# Ploughley Road

AMBROSDEN

Design and Access Statement Addendum March 2023

This document has been prepared as an addendum to the Design and Access Statement submitted for the outline application for 120 dwellings at Ploughley Road, Ambrosden, on behalf of Bellway Homes.

project title
Land off Ploughley Road, Ambrosden, Oxfordshire

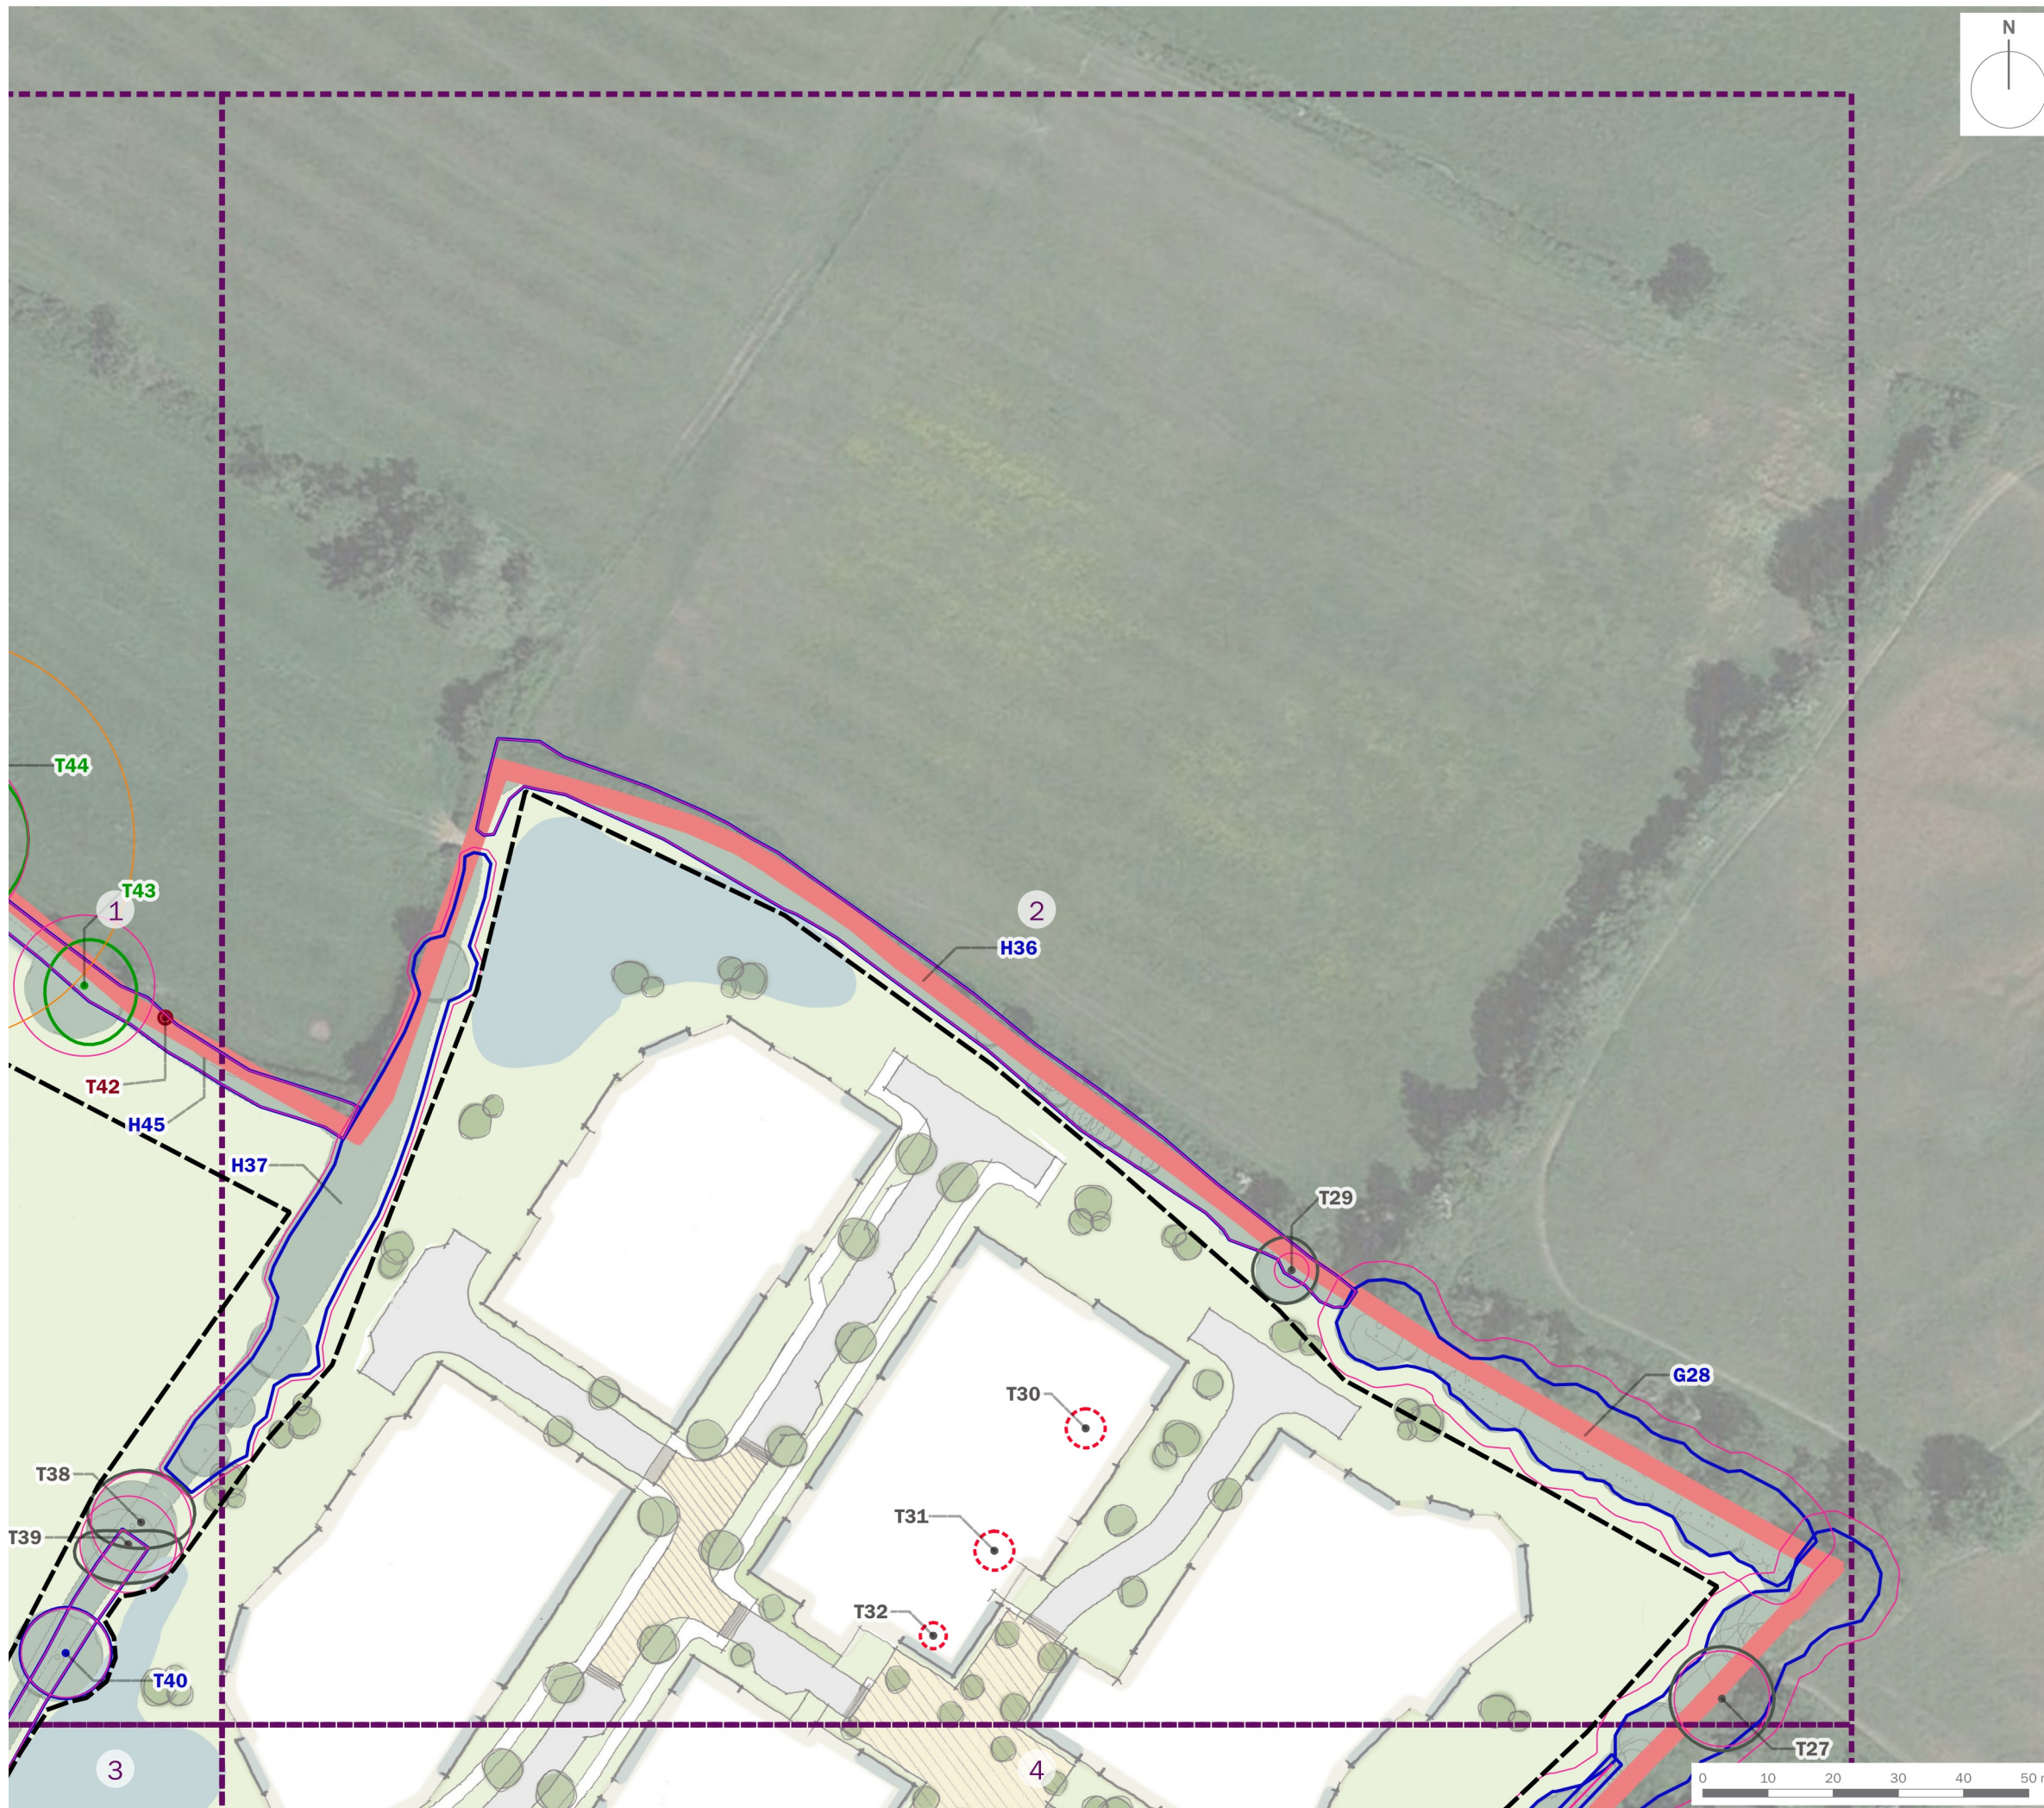
The adjacent image shows an extract of the tree protection plan, (page 12 of Arboricultural Addendum Statement) overlaid over the above framework plan to indicate the Arboricultural impact of the pedestrian link in this location.

The pedestrian link as currently proposed in this location would result in the partial loss of a category C tree G25 as pictured.

In order to mitigate the impact of the pedestrian access on the existing boundary vegetation as described on Page 3, it is proposed that the pedestrian access point (C) is relocated approximately 15 metres north, as shown in the adjacent extract of the updated Framework Plan.

The amended access point will be positioned outside of the RPA's and will still provide direct access to the existing bridleyway leading on to West Hawthorne Road.

**LEGEND**

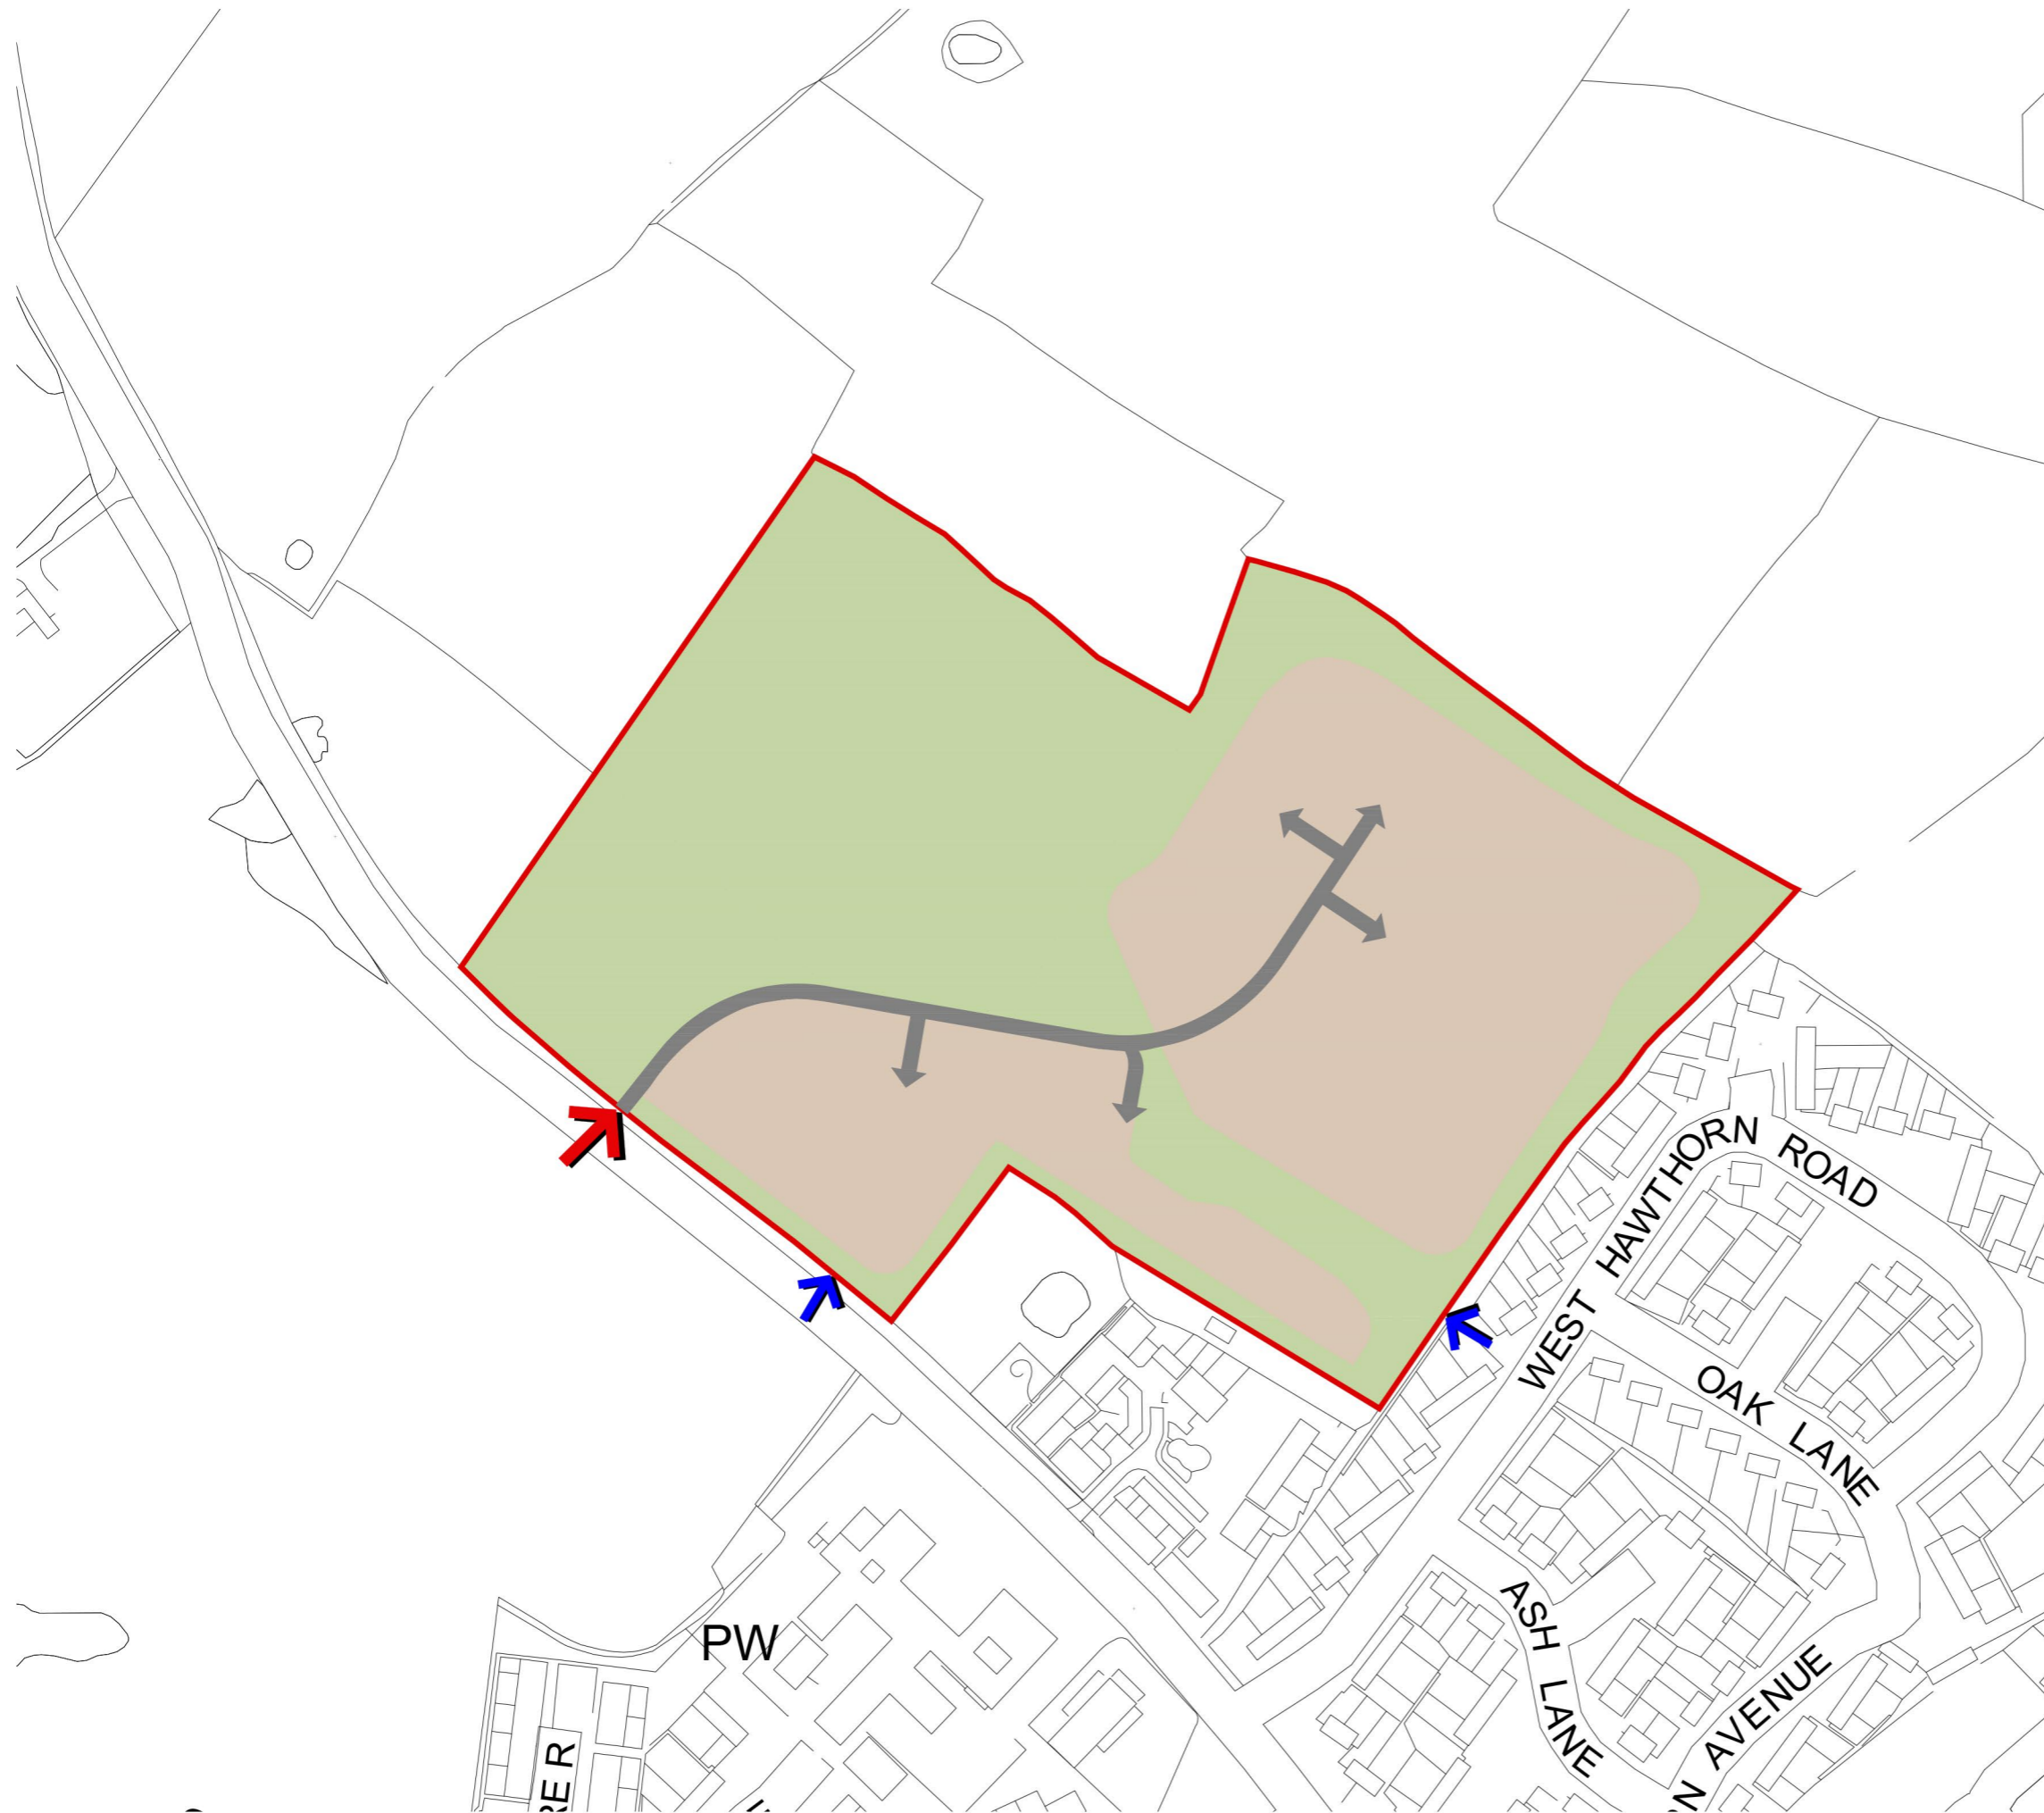
## AMENDMENT TO PROPOSALS

The image below shows the new location of the pedestrian link on the Access Parameter Plan 9603 PP-A which will be submitted alongside this document.
